## Appeal Decision

**Appeal Ref: APP/R5510/W/24/3357815**

**43 Rochester Road, Northwood, Hillingdon HA6 1NJ**

PROPOSED DWELLING  
REAR ELEVATION

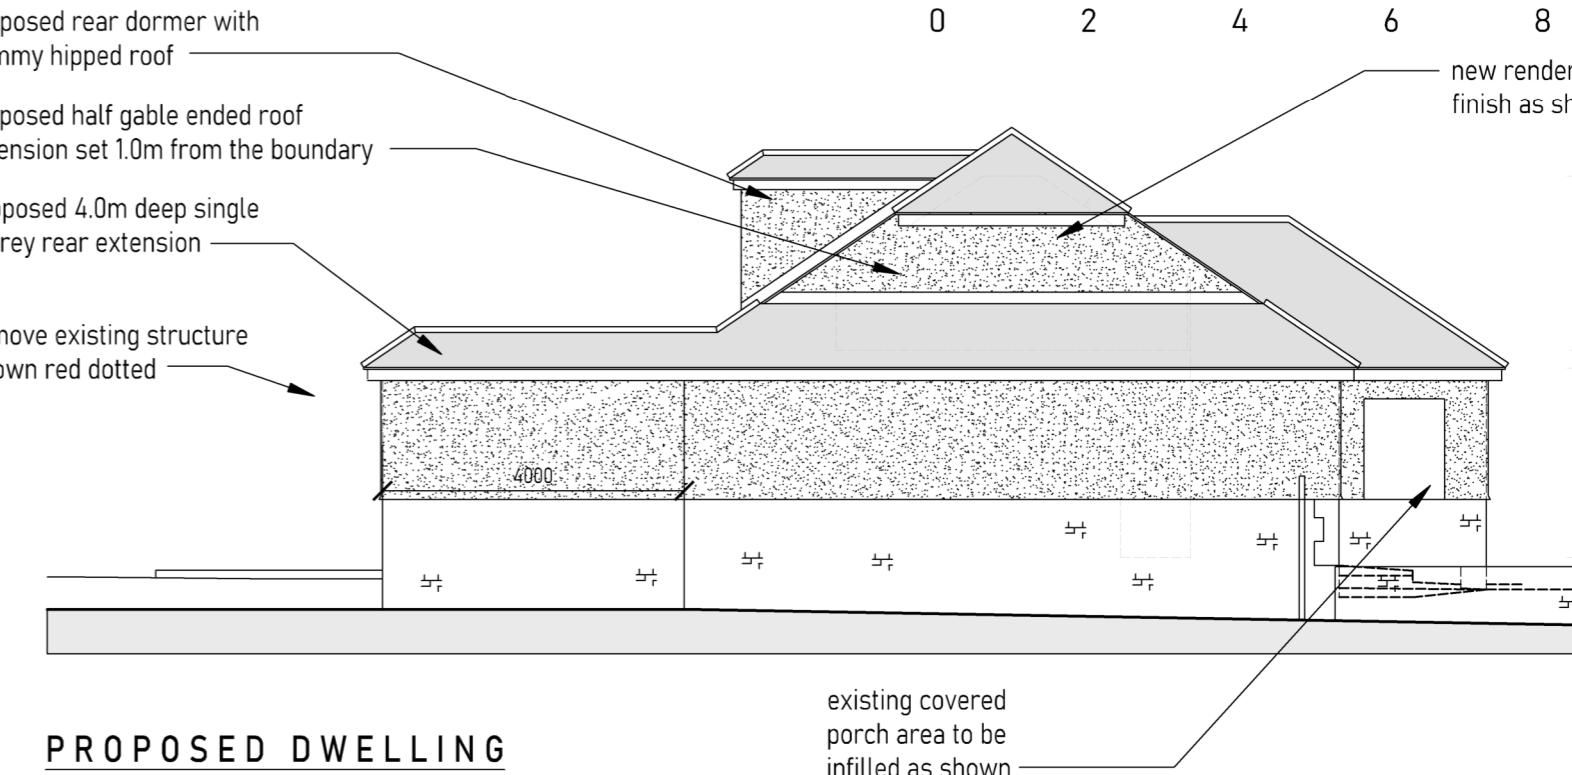
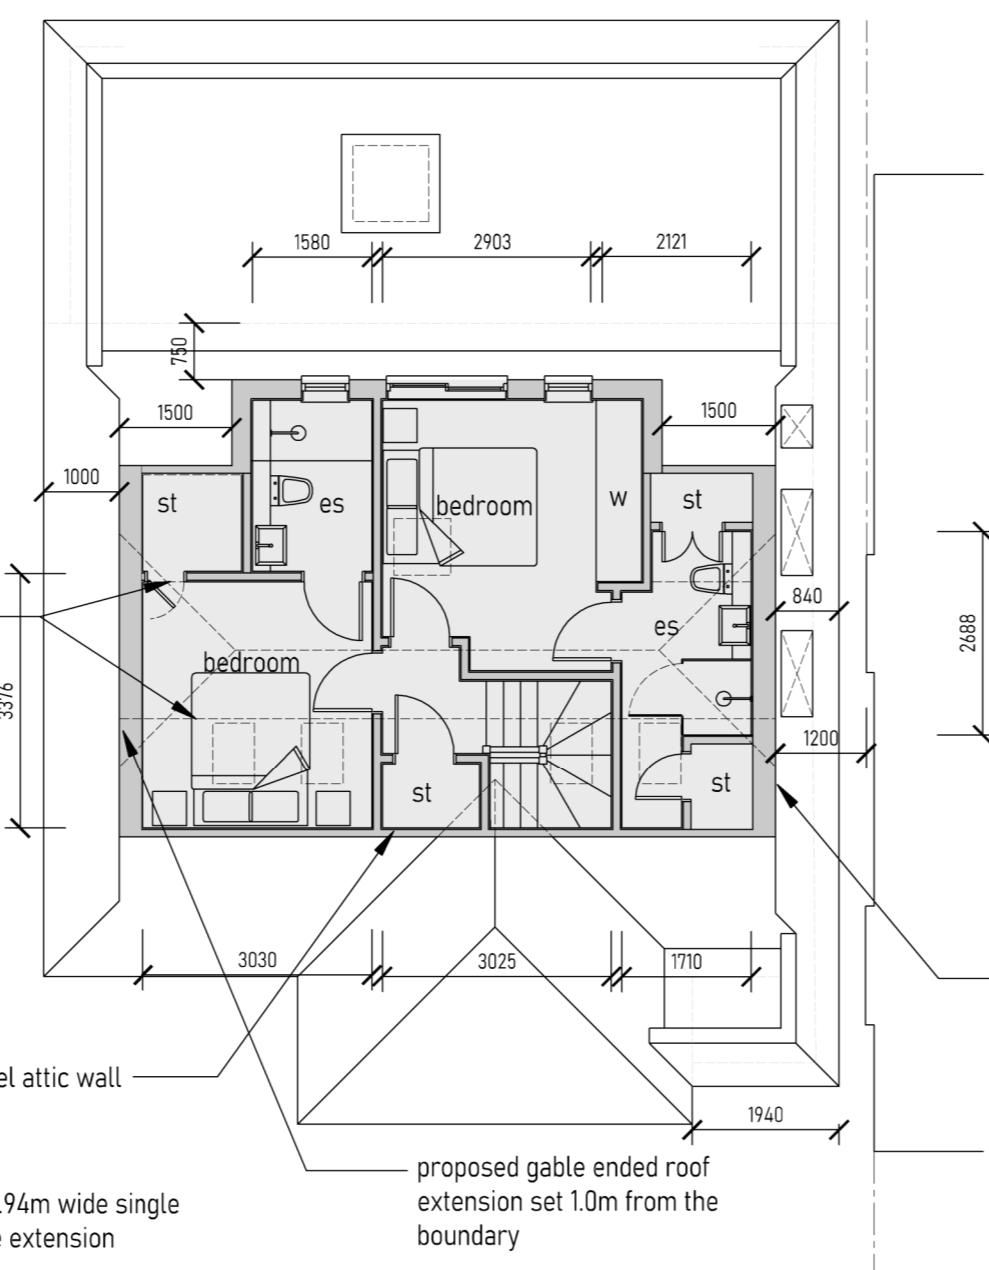
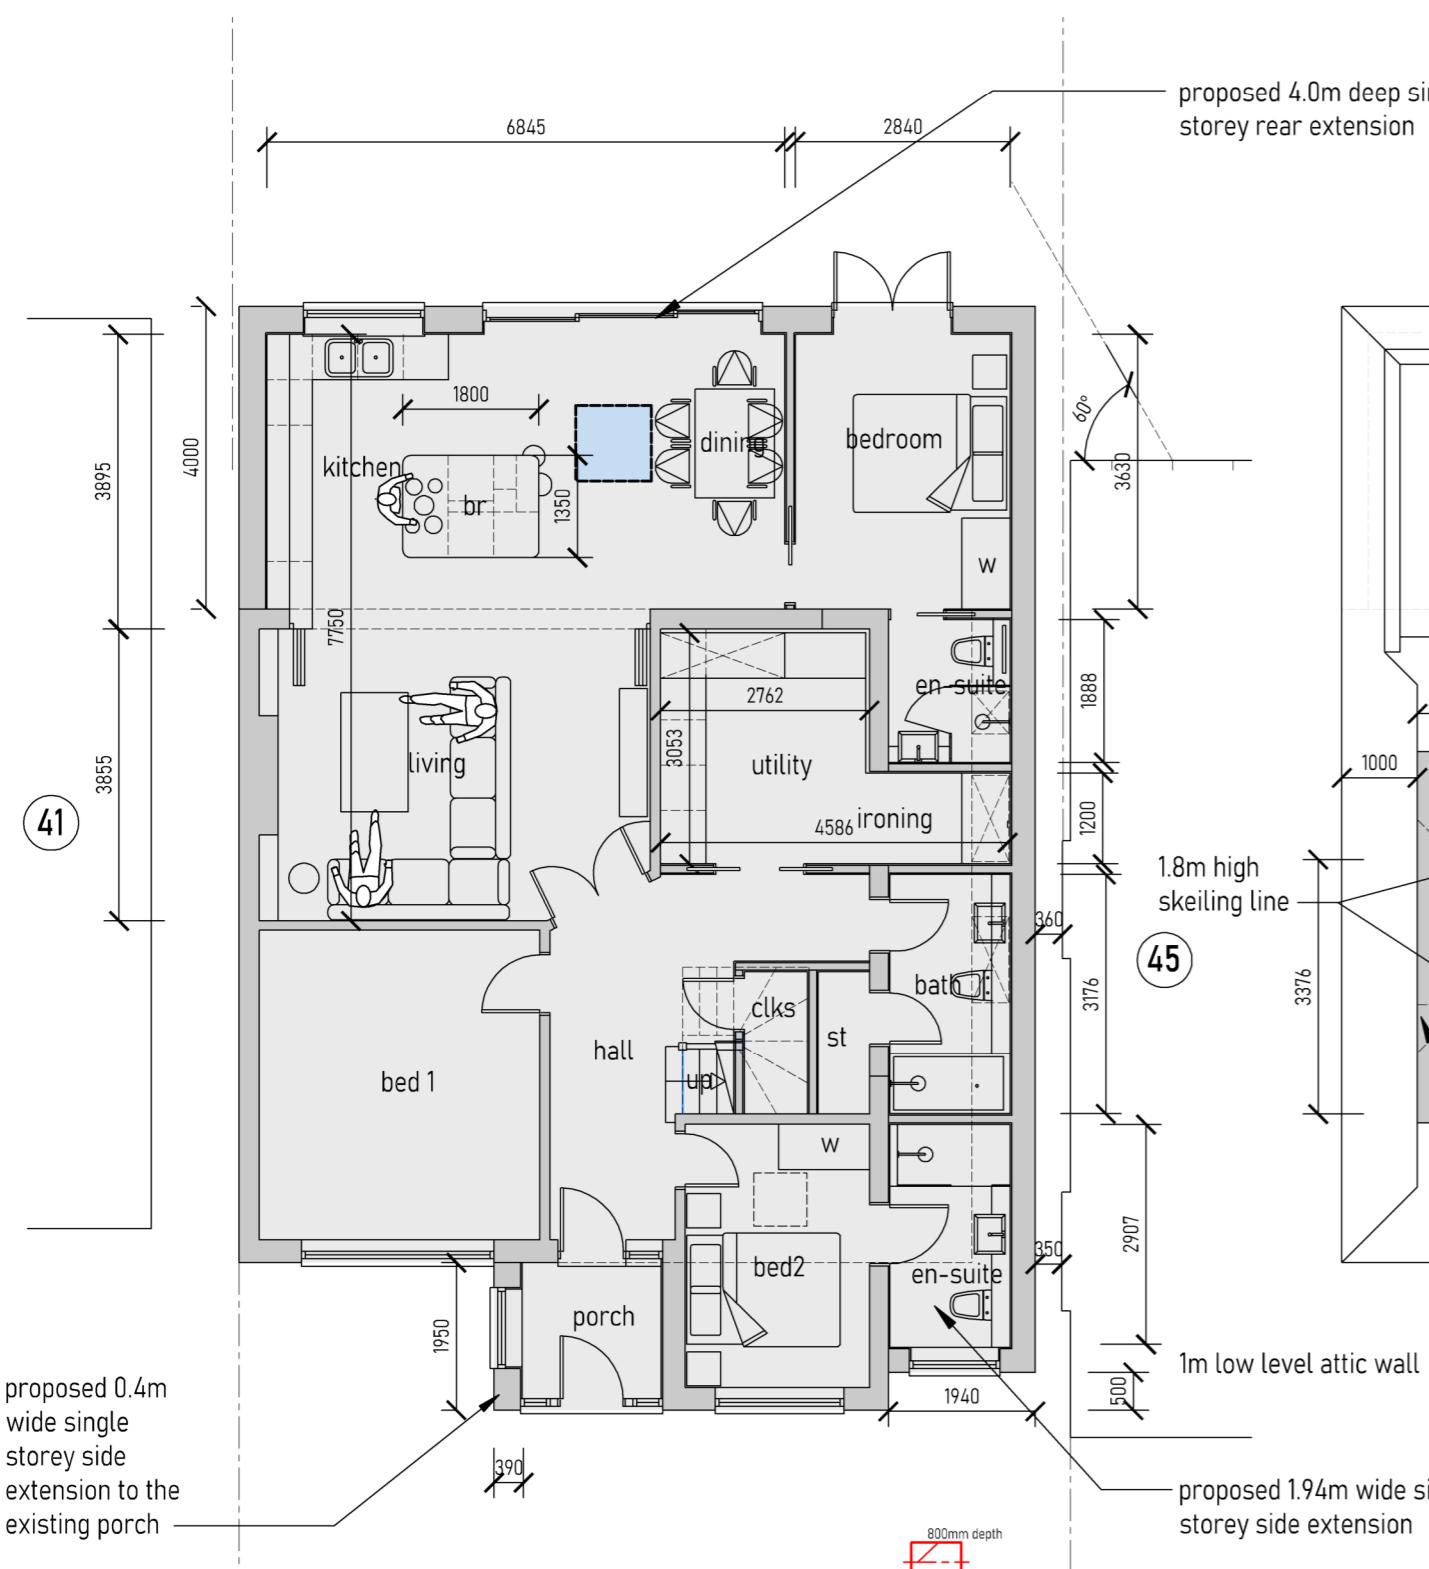
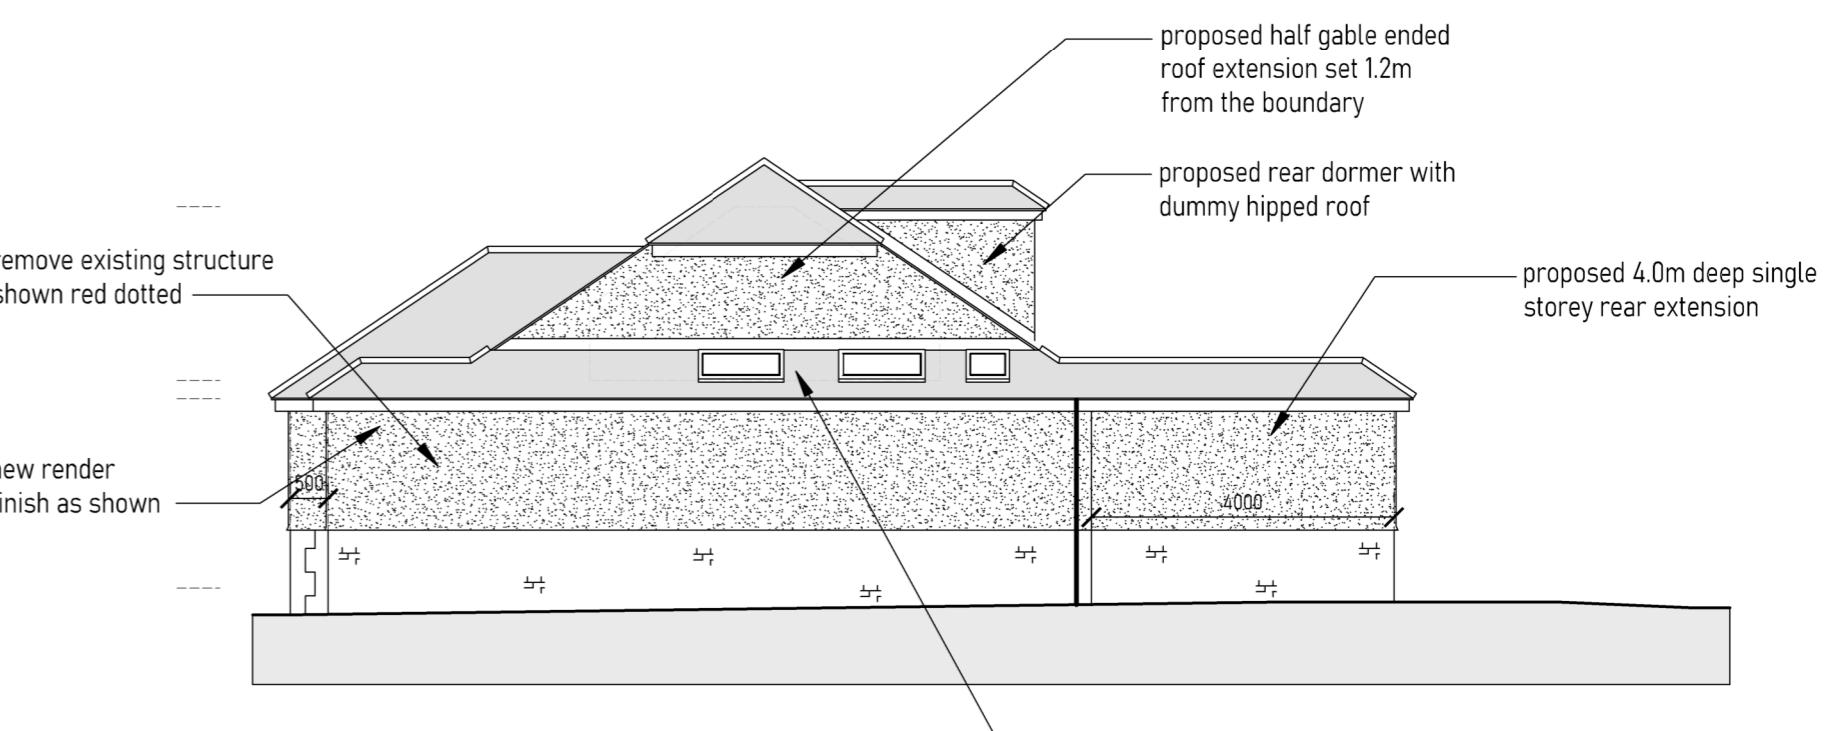
5. The appeal property benefits from an extant permission for front, rear and side extensions and a loft conversion<sup>1</sup>. The principal difference between the permitted scheme and the appeal proposal is that the proposed rear dormer window is wider on the appeal scheme and would be clad in render instead of hanging tiles. The key issue therefore, having regard to the overall effect of the scheme, is whether the proposed wider rear dormer window, clad in render, would have an acceptable effect on the character and appearance of the area.

6. Policy DMHD 1E of the London Borough of Hillingdon Local Plan Part 2 Development Management Policies Adopted Version 16 January 2020 (LPP2) contains detailed design criteria for roof extensions. Taking the already permitted enlargement to the roof to be the original roof for the purposes of the policy, the proposed dormer window would extend across approximately two thirds of the roof, retaining a significant area of roof slope either side of it. It would sit below the ridge line of the roof and, by virtue of the angled parapet roof above the single storey rear extension, would be perceived as retaining a roof slope above the eaves line. Consequently, the proposal would be subservient to the scale of the roof and would not dominate the appearance of the bungalow, in accordance with Policy DMHD 1E.

7. I saw on my site visit that the adjacent property, no 41 Rochester Road, has been converted into a chalet bungalow with two large flat roofed dormer windows at the rear. The dormers sit just below the ridge line and extend across most of the width of the property, with a gap between the two dormers. The overall bulk and massing of the proposed dormer window at No 43 would be comparable with that of the adjacent pair of dormer windows, indicating that the proposal would not be out of place with the character of this run of properties when seen from the rear.

9. The proposed rendering of the dormer window would contrast with the appearance of the existing tiled roof, and I agree with the Council that the most appropriate material would be hanging tiles. Since external facing materials are a detailed matter which are capable of being conditioned, and as the appellant has indicated a willingness to accept a condition requiring details of the external materials of the dormer window to be submitted to and approved by the Council, I propose to attach a planning condition to this affect.

- 3) Prior to installation of the external materials on the development hereby permitted, details of the roof and dormer materials and external surfaces shall have been submitted to and approved in writing by the Local Planning Authority. Details should include information relating to make, product/type, colour and photographs/images. Thereafter the development shall be constructed in accordance with the approved details and retained as such.
